Application for Planning Permission for Works or Extension to a Dwelling

Development: Dropped kerb vehicle access on to driveway.
Location: 80 Worthing Road Rustington BN16 3LL

Location Plan

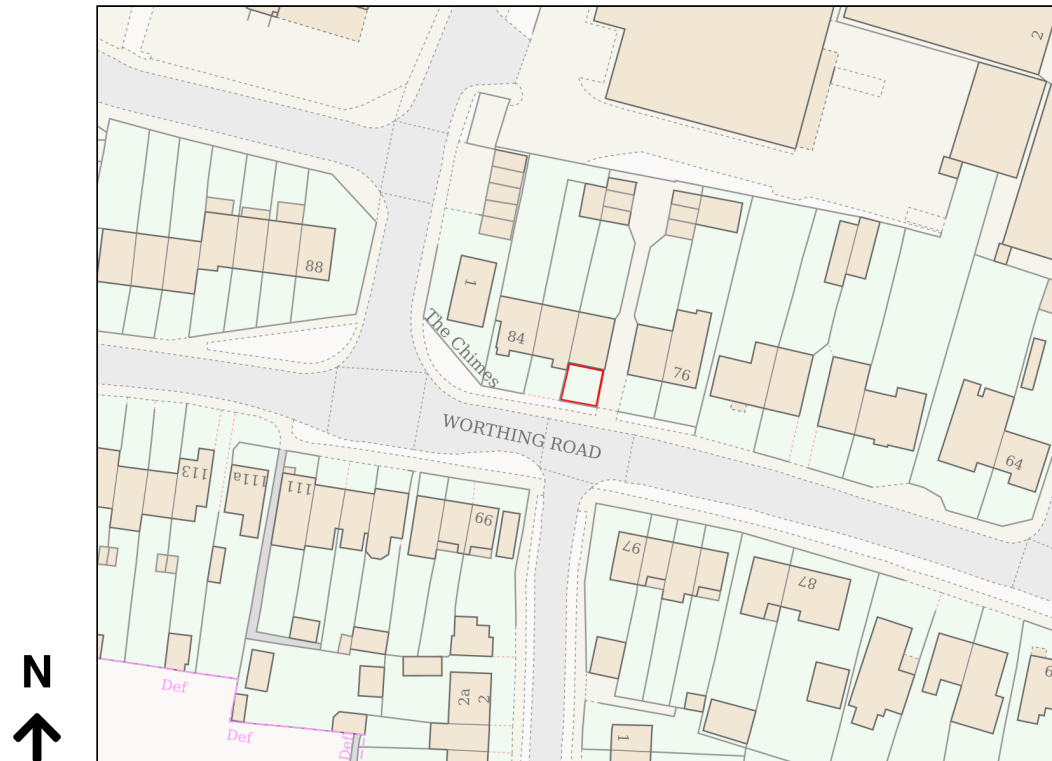
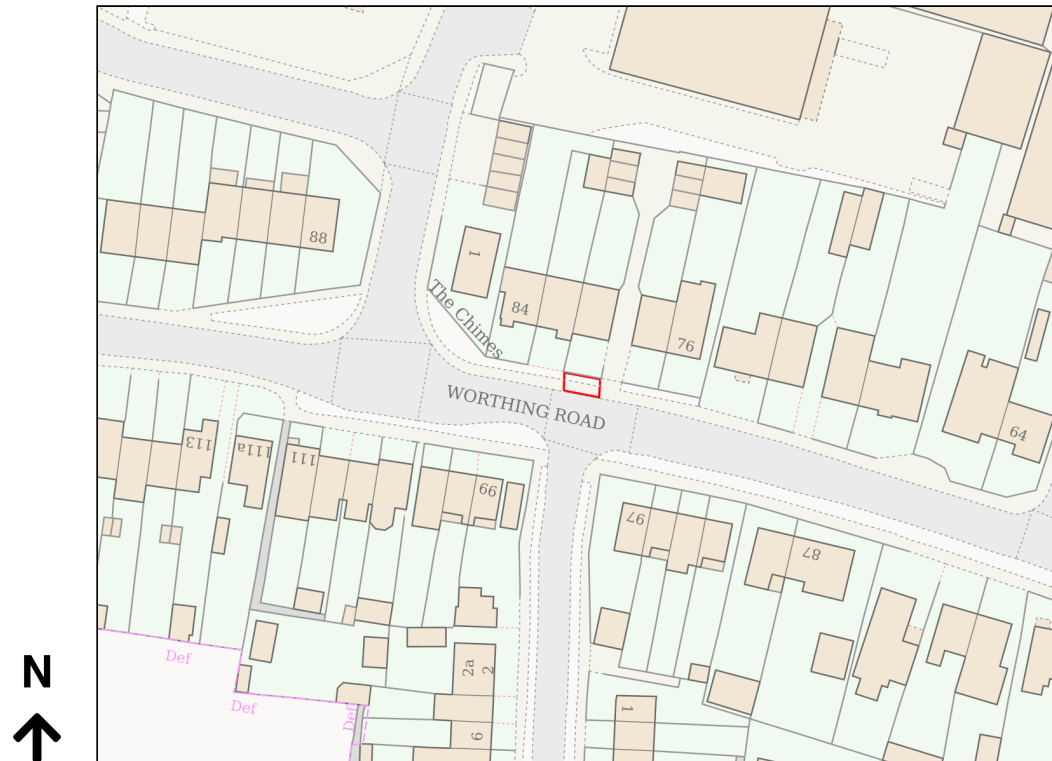
Please amend the red line on the location plan to cover all land affected (this includes the pavement).
